Our ref: Sport and Wellbeing Centre, Roseville College-Mod-1 (SSD-9912-Mod-1)

25 March 2022

Subject: Request for Additional Information

Sheet: EPM05-DA-101

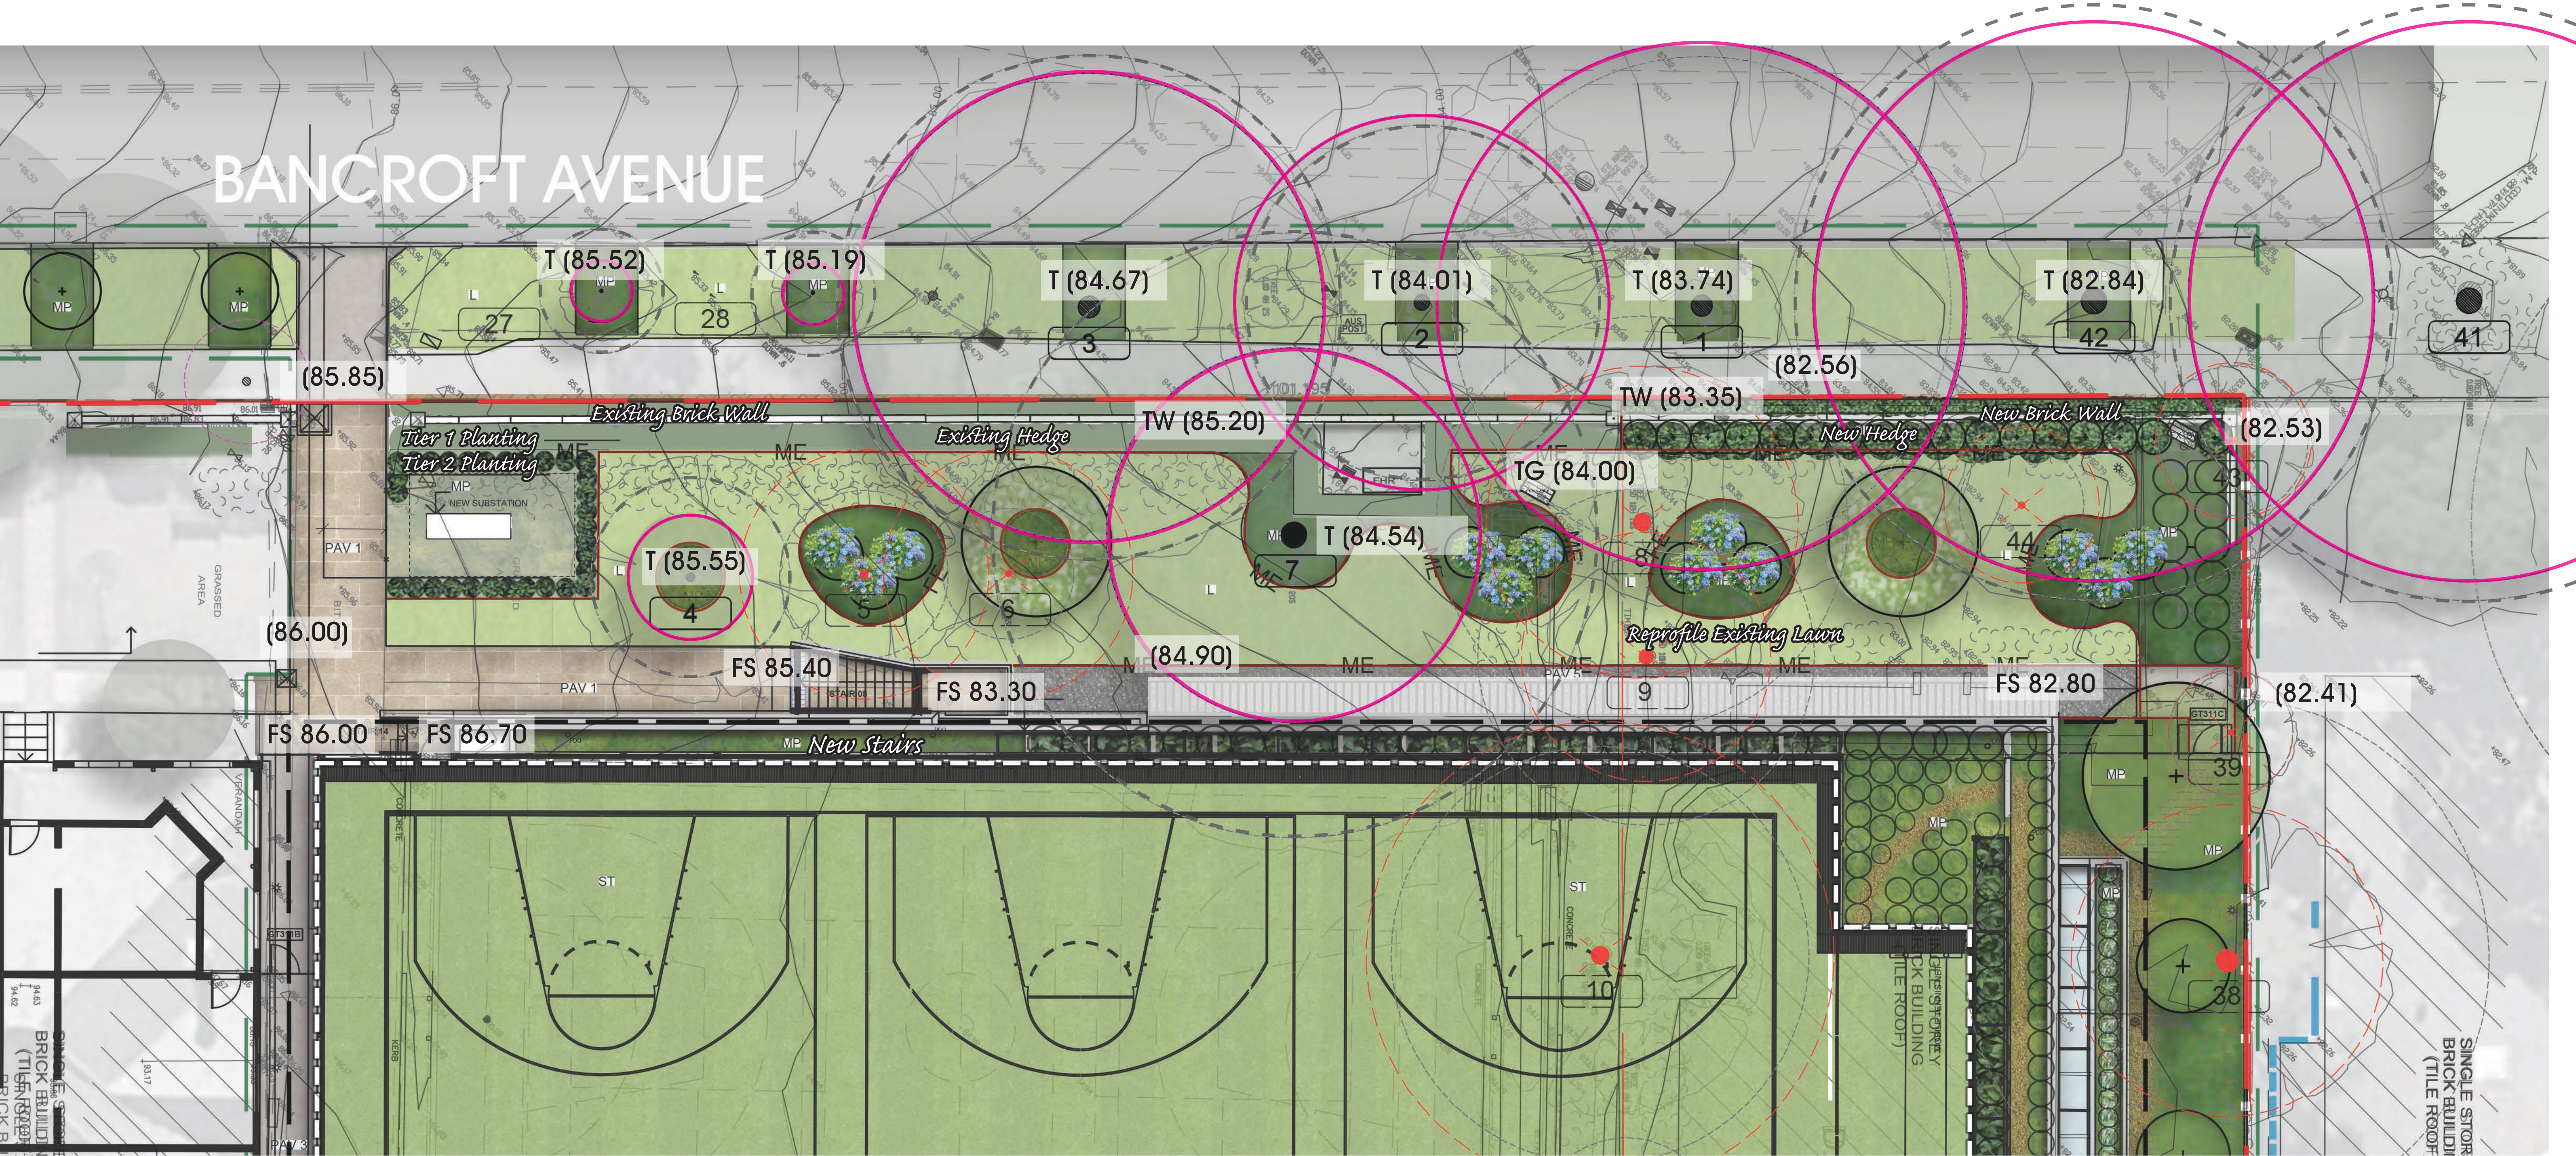
- Confirm whether the final landscape plans submitted as part of the modification application had been sent to the owner at 39 Bancroft Avenue.
- Provide evidence that the Pyrus Calleryana along the boundary at the northern end has been moved 1.5m further north and the owner at 39 Bancroft Avenue has confirmed they are satisfied with this positioning on the final landscape plans.

Sheet: EPM05-DA-102

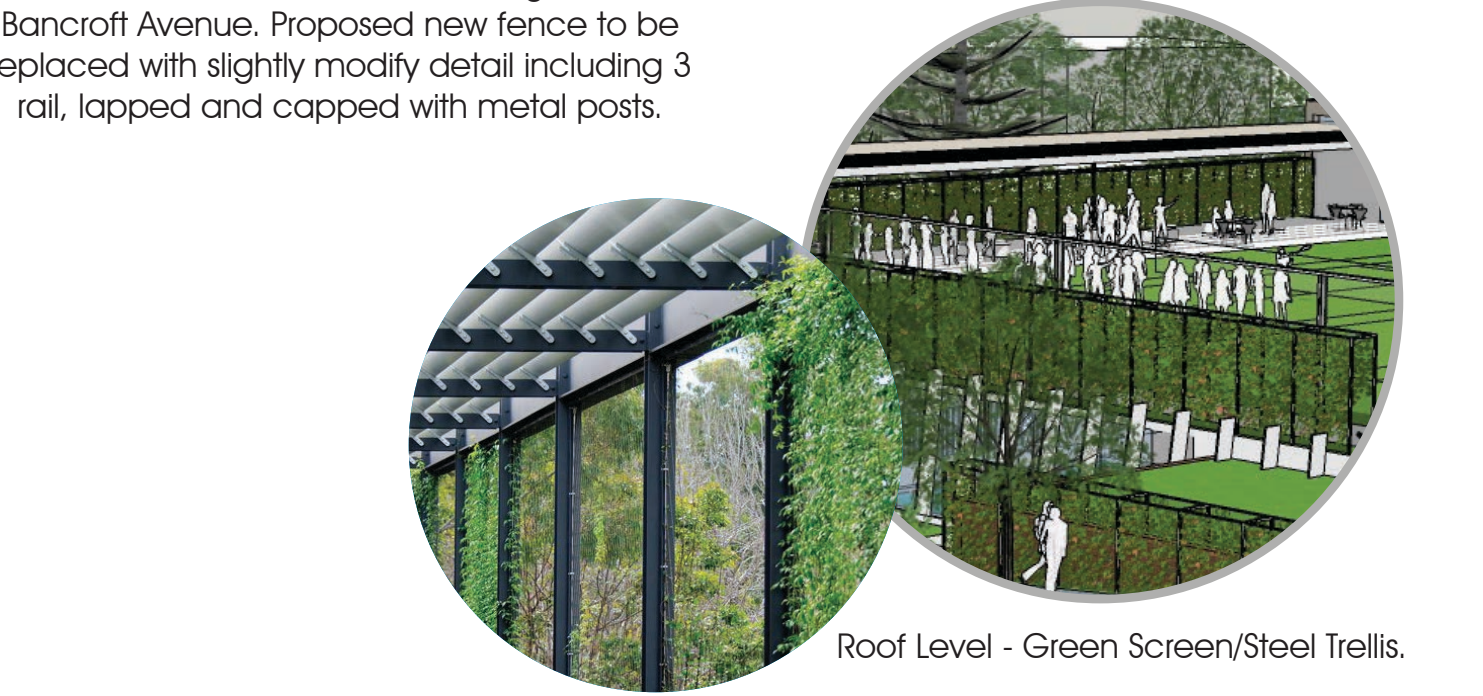
- Landscape plans EPM05-DA-104 and EPM05-DA-103 reference that the final selection of boundary planting is subject to consultation with the owner of 39 Bancroft Avenue in accordance with Consent Condition B26. The plans suggest there are two options, either *Michelia figo* (Port Wine Magnolia) or *Lagerstroemia indica* 'Natchez'. You are requested to confirm, which option is proposed and provide revised plans including the chosen species.
